**WEST SUSSEX COUNTY COUNCIL
COUNTY HIGHWAYS CONSULTATION RESPONSE**

SUBJECT: AL/123/17/PL - Demolition of existing dwelling & erection of 1 No. dwelling (resubmission following AL/83/17/PL).

Mildmay, Hook Lane, Aldingbourne, PO20 3TE

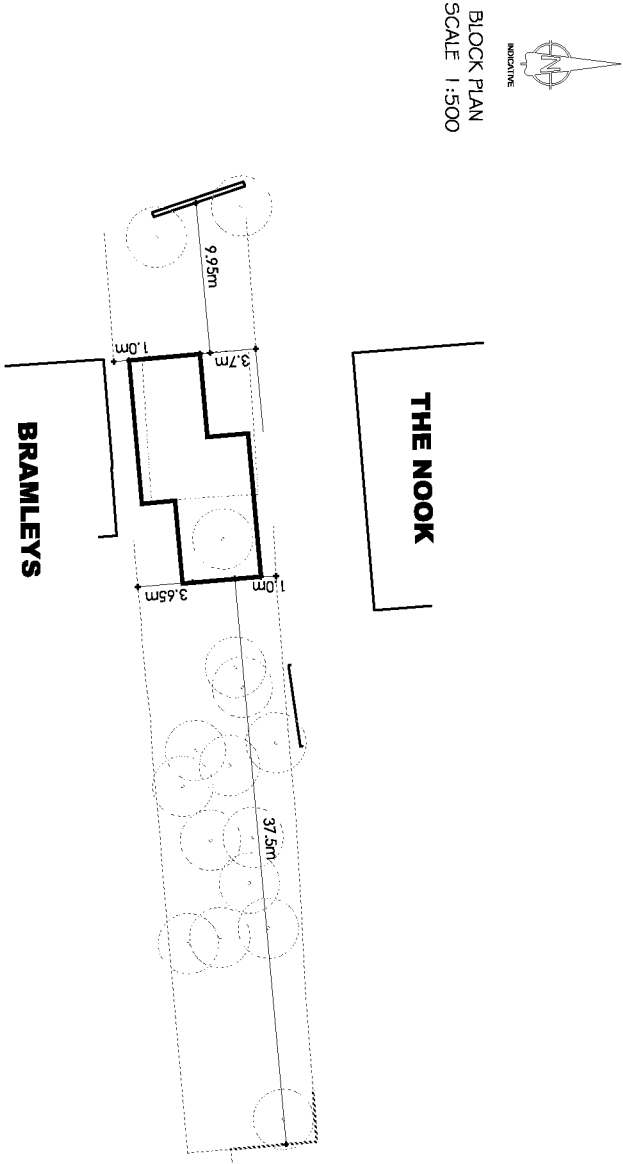
An appropriate quantity of on-site parking is proposed. The dwelling should also be provided a secure and covered cycle parking provision.

The existing point of access is to be relocated to the norther extent of the western boundary onto Hook Lane, adjacent to The Nook. The proposed point of access will be afforded similar visibility to that of the existing access so no concern would be raised. The access works must be implemented under licence to a specification obtained from WSCC Highways.

The existing access will be redundant as a result of these relocation works. Therefore the access should be closed in accordance with plans and details to be submitted to and approved by the Local Planning Authority. Again a licence and specification will be required from WSCC Highways to implement these closure works.

No part of the development shall be first occupied until such time as the vehicular access serving the development has been constructed in accordance with the approved drawing.

No part of the development shall be first occupied until such time as the existing vehicular access onto Hook Lane has been physically closed in accordance with plans and details submitted to and approved in writing by the Local Planning Authority.

No part of the development shall be first occupied until the car parking has been constructed in accordance with the approved site plan. These spaces shall thereafter be retained at all times for their designated purpose.

No part of the development shall be first occupied until covered and secure cycle parking spaces have been provided in accordance with plans and details submitted to and approved by the Local Planning Authority.
